Rosefield Solar Farm

Schedule of Changes to the draft DCO ([Tracked](#))

EN010158/APP/~~3.1.3~~[3.1.4](#)
Revision ~~3~~[4](#)
Deadline ~~23~~
~~April~~[May](#) 2026
Rosefield Energyfarm Limited

Schedule of Changes to the draft DCO

PIN REFERENCE NUMBER: EN010158/APP/2.4.2		REVISION: 02
DATE: OCTOBER 2025	DRAWN: PF	SCALE: 1:2,500 at A1

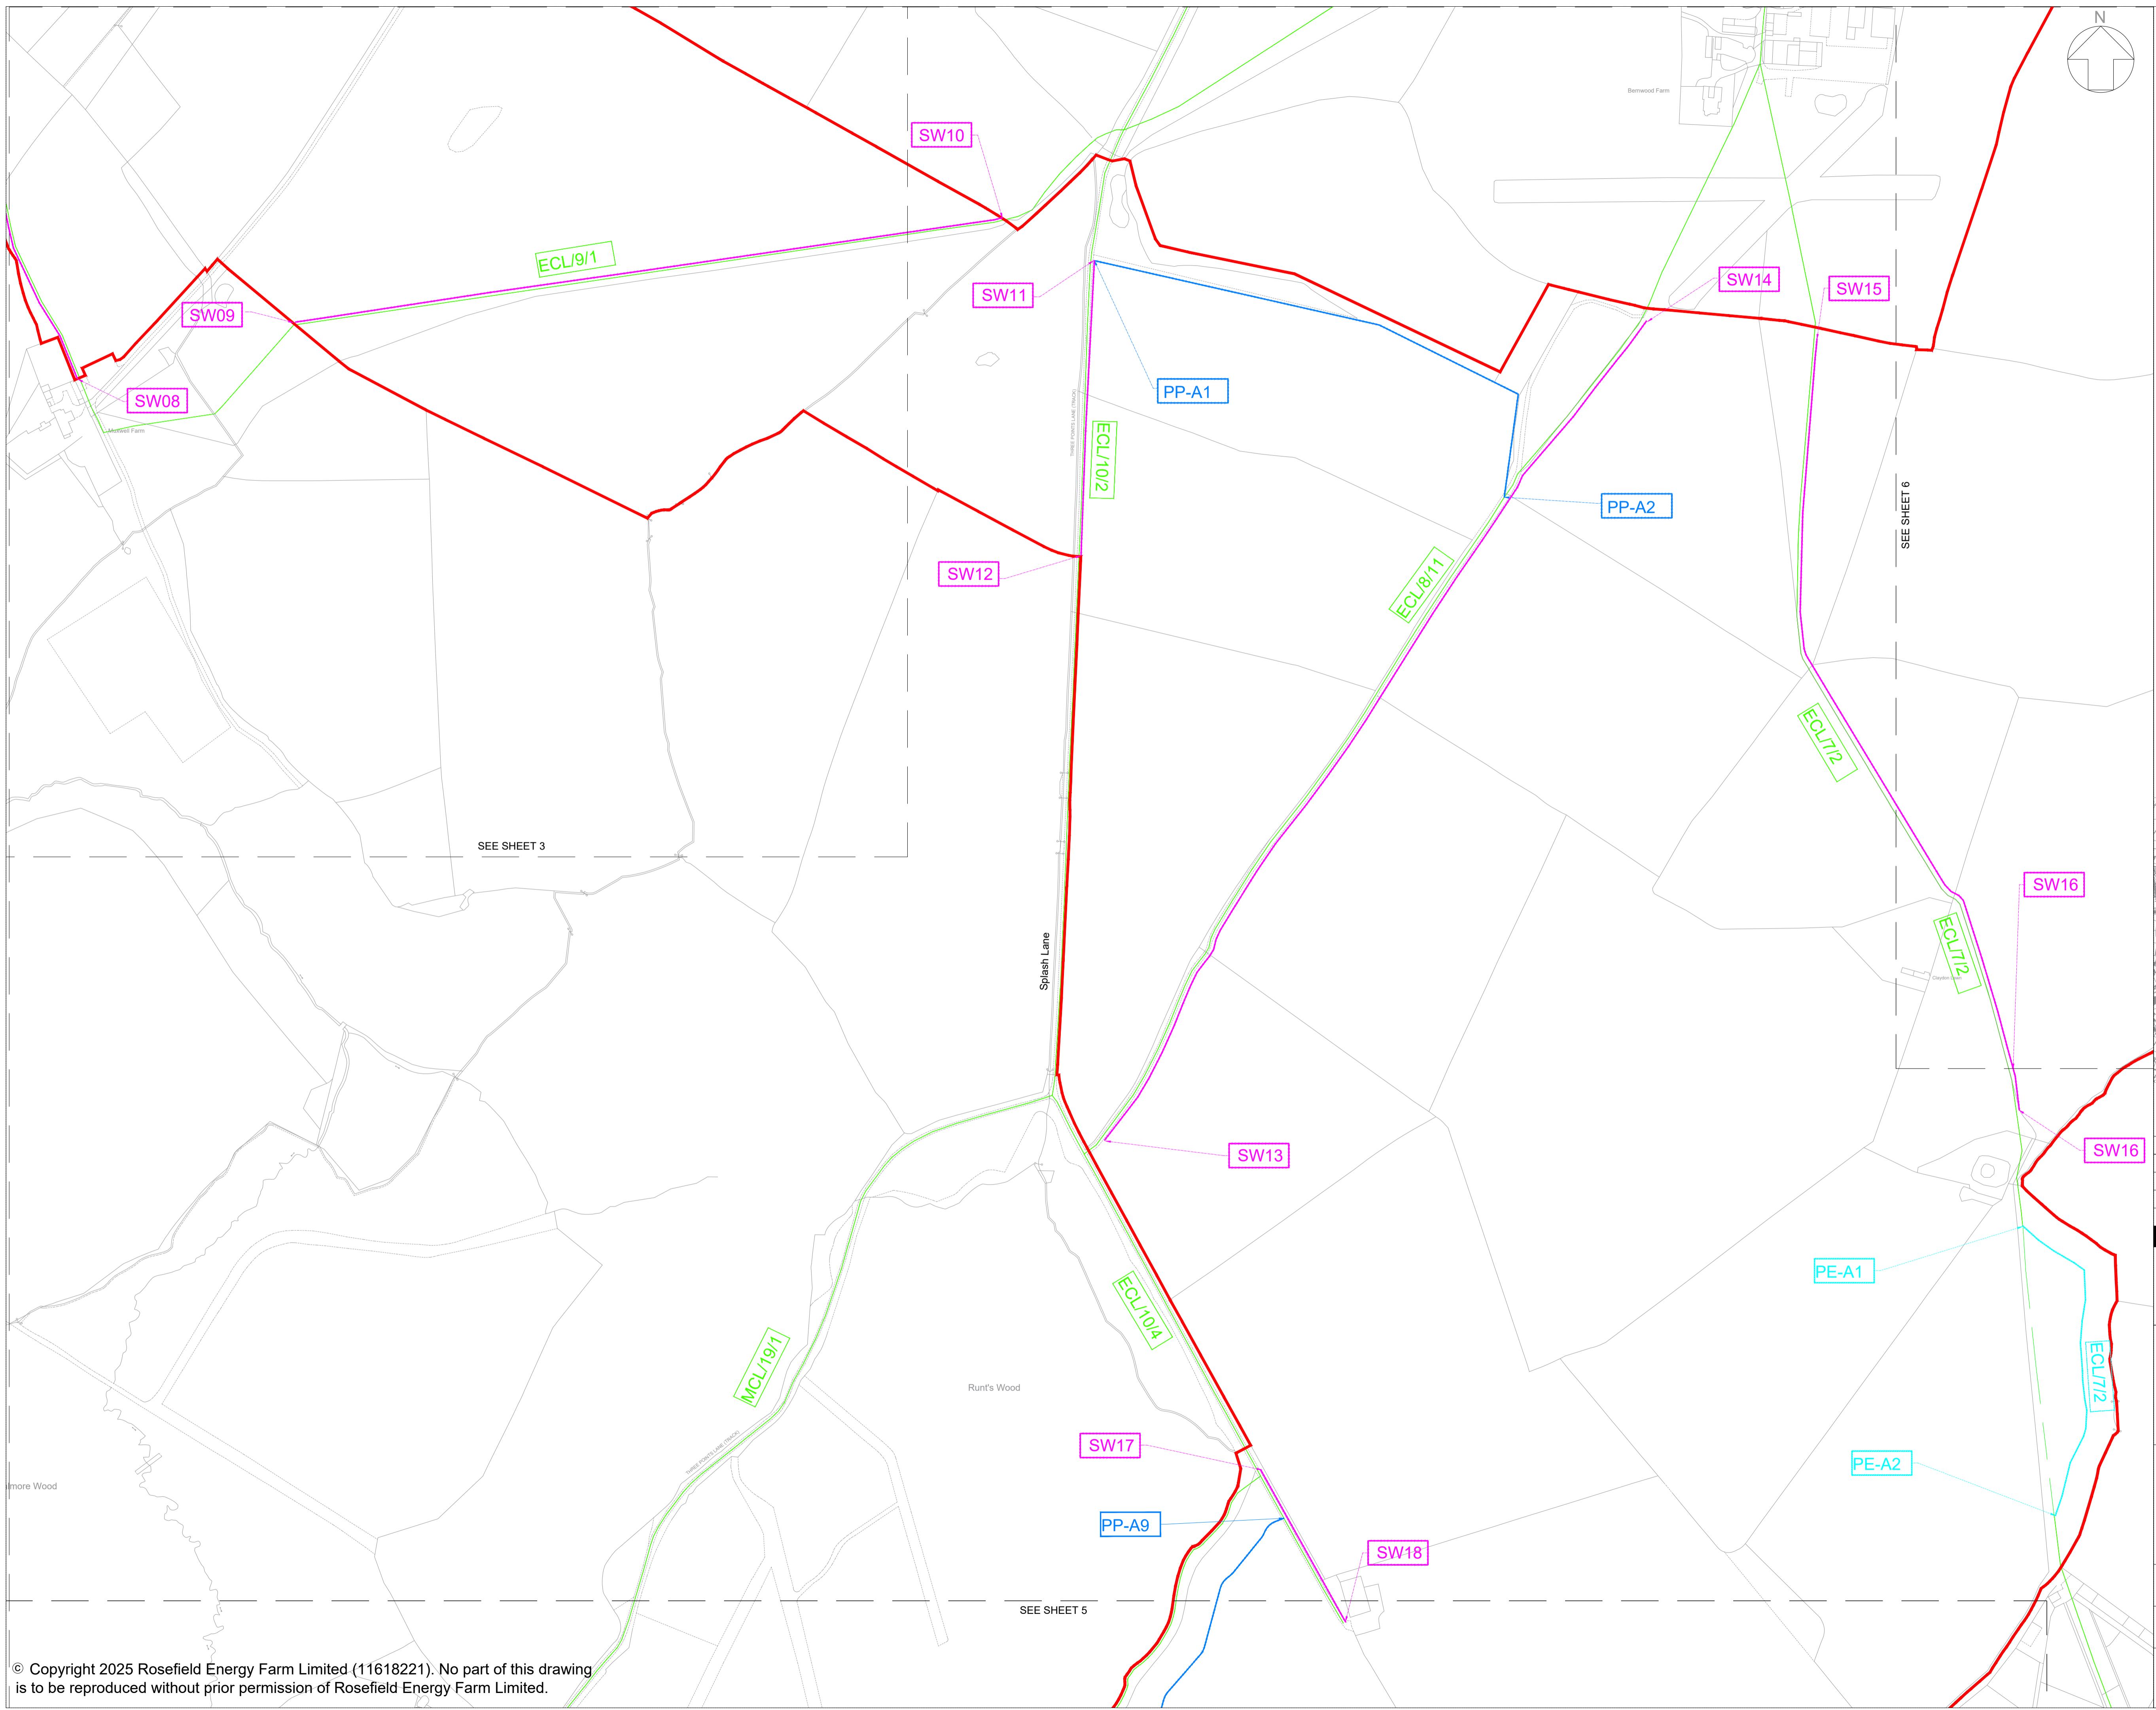
Reference	Change	Reason for Change	Deadline								
	<p>Environment Agency and Anglian Water Services Limited or its successor in function as the relevant water undertaker.</p> <p>(2) The written details under sub-paragraph (1) must be substantially in accordance with the outline drainage strategy.</p> <p>(3) Any approved strategy must be implemented as approved and maintained throughout the construction and operation of the authorised development.</p>	<p>representation [RR-081] and AWS' relevant representation [RR-012], where each requested to be a consultee.</p>									
<p>Schedule 2, Requirement 14 (Operational noise)</p>	<p>14. – (1) No part of Work Nos. 1 to 5 may commence until an operational noise assessment containing details of how the design of that numbered work has incorporated mitigation to ensure the operational noise rating levels as set out in paragraph 13.9.19 of chapter 13 of the environmental statement are complied with for that part has been submitted to and approved by the relevant planning authority.</p>	<p>Addition of reference to more specific operational noise limits on the face of dDCO.</p>	<p>1</p>								
<p>Schedule 6, Part 1 (PRoW to be permanently stopped up and diverted)</p>	<table border="1"> <thead> <tr> <th data-bbox="443 826 725 979"><i>(1) Area</i></th> <th data-bbox="725 826 1008 979"><i>(2) Public right of way to be stopped up</i></th> <th data-bbox="1008 826 1290 979"><i>(3) Extent of stopping up</i></th> <th data-bbox="1290 826 1572 979"><i>(4) New public right of way to be substituted / provided</i></th> </tr> </thead> <tbody> <tr> <td data-bbox="443 979 725 1319"> <p>District of Buckinghamshire</p> </td> <td data-bbox="725 979 1008 1319"> <p>SCL/12/2</p> </td> <td data-bbox="1008 979 1290 1319"> <p>For a distance of 320 190 metres between points PE-A7 PE-A10 and point SW04 as shown on sheet 1 of the streets, access</p> </td> <td data-bbox="1290 979 1572 1319"> <p>New public footpath to be provided between points PE-A7, PE-A5 and its intersection with SCL/12/1 as shown by a cyan line on sheet 1 of</p> </td> </tr> </tbody> </table>	<i>(1) Area</i>	<i>(2) Public right of way to be stopped up</i>	<i>(3) Extent of stopping up</i>	<i>(4) New public right of way to be substituted / provided</i>	<p>District of Buckinghamshire</p>	<p>SCL/12/2</p>	<p>For a distance of 320 190 metres between points PE-A7 PE-A10 and point SW04 as shown on sheet 1 of the streets, access</p>	<p>New public footpath to be provided between points PE-A7, PE-A5 and its intersection with SCL/12/1 as shown by a cyan line on sheet 1 of</p>	<p>Reduction in extent of stopping up to SCL/12/2 to address Buckinghamshire Council's relevant representation [RR-026] to avoid creation of a 'dead-end'.</p>	<p>1</p>
<i>(1) Area</i>	<i>(2) Public right of way to be stopped up</i>	<i>(3) Extent of stopping up</i>	<i>(4) New public right of way to be substituted / provided</i>								
<p>District of Buckinghamshire</p>	<p>SCL/12/2</p>	<p>For a distance of 320 190 metres between points PE-A7 PE-A10 and point SW04 as shown on sheet 1 of the streets, access</p>	<p>New public footpath to be provided between points PE-A7, PE-A5 and its intersection with SCL/12/1 as shown by a cyan line on sheet 1 of</p>
